DECISION DELEGATED TO HEAD OF PLANNING

Application No: H16-0052-22 **Applicant:** Seagate Homes

Proposal: Details relating to construction management plan (Condition 12 of H16-0668-16)

Location: Millfield Nursery Spalding Common Spalding

Project:	PROPOSED RESIDENTIAL DEVELOPMENT, MILLFIELD NURSERY, SPALDING COMMON, SPALDING	
Drawing:	CONSTRUCTION MANAGEMENT PLAN	
Drawn:	MD	Date: 04.02.2021
Status:	PLANNING	Scale: 1:500 @ A1
Drawing Number:	MNSC-SH-SP-CMP-1000 C

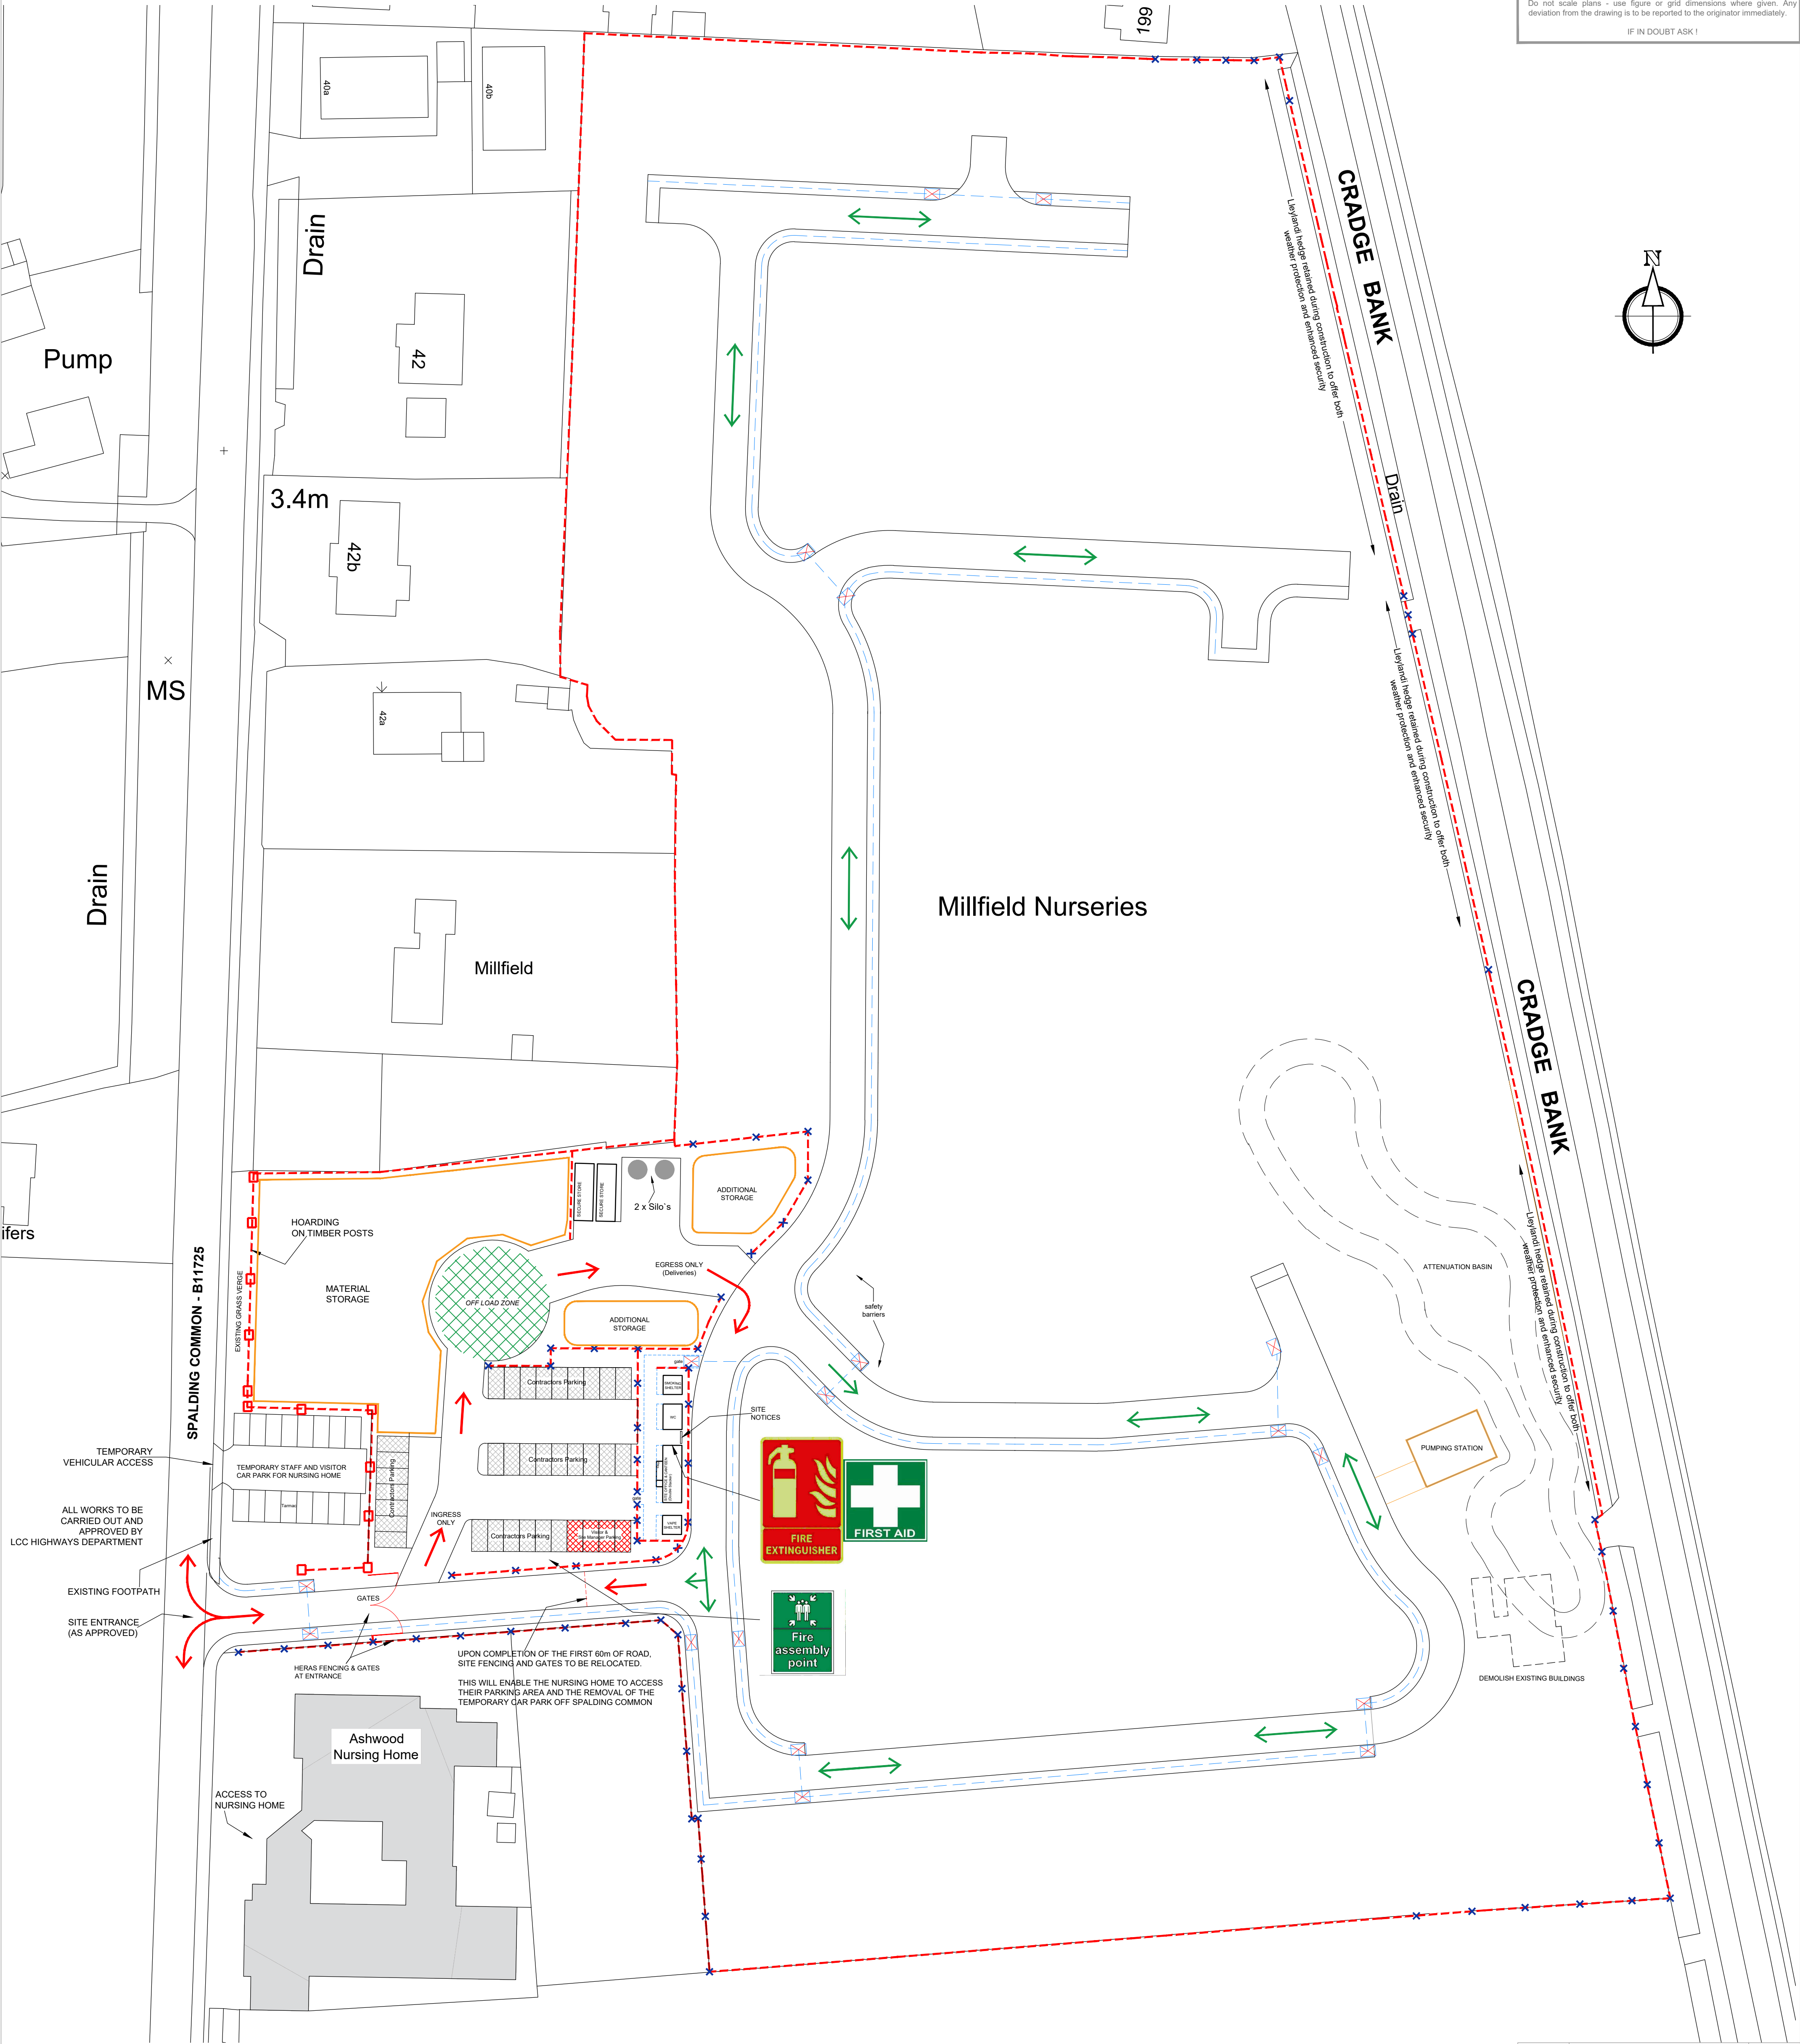
The submitted Construction Method Statement document is satisfactory as far as it goes but in order to be able to effectively enforce against activities that typically attract complaints, it is suggested that the document should also include commitments to conduct all loading and unloading

of materials entirely within the site and to employ the services of a road sweeping vehicle to routinely remove mud and any other site-derived detritus from the public highway.

SHDC Case officer note: The comments above relate to the revised details submitted by the applicant as their first revision. As a result of these comments the submission was further revised to address these matters.

The concerns of LCC have been taken in to account.
